Erection of 1 No. 4 bed dwelling, formation of new access & felling of 4 No. trees to the rear of the site. This application affects the character & appearance of the Craigweil House Conservation Area.

Land Between 8 And 12 Wychwood Close Aldwick

Thank you for your internet representation made on 20th September 2018 which has been recorded as '**an objection**' with the comments as follows:

DRAWING TITLE
Site Plan, Block Plan and Location Plan

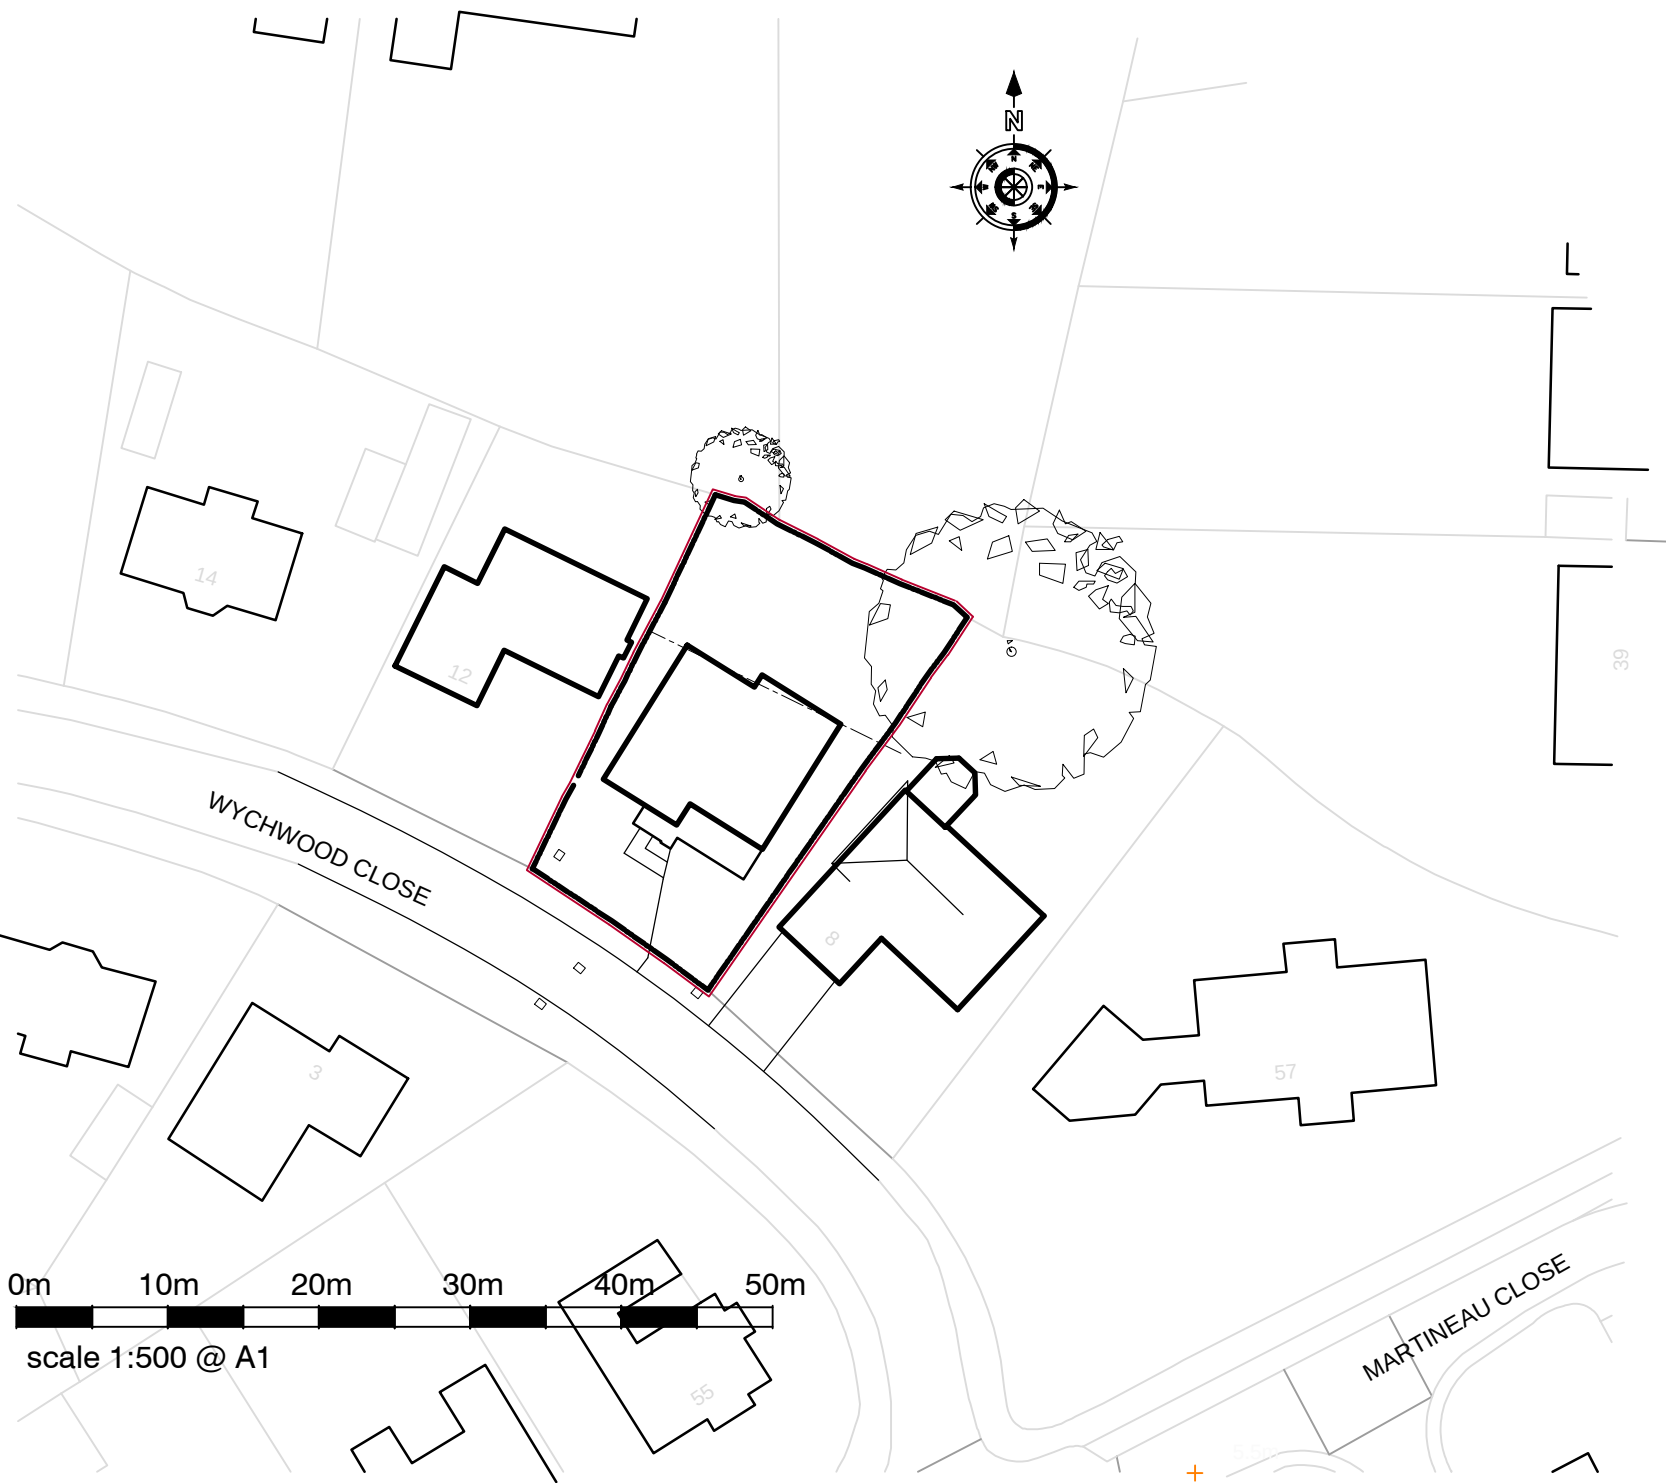
Although I support the long overdue development of this plot I do have several concerns regarding this particular proposal, 1: The plan view of the proposal shows the house & garage in line with the garages of the two adjacent properties however, the two neighboring houses lay back from their garages this makes the proposal in my opinion a little overbearing. 2: The balcony to the front of the property will directly overlook my rear garden. 3: The double garage it appears will only accommodate one car due to the utility room encroaching, with road parking discouraged in general & due to the very narrow nature of Wychwood Close (which like all the estate roads has no footpath) I feel a double garage should, if required at the very least be able to accommodate two cars. In conclusion I do not object in principle to this proposal, but only to the concerns I have raised.
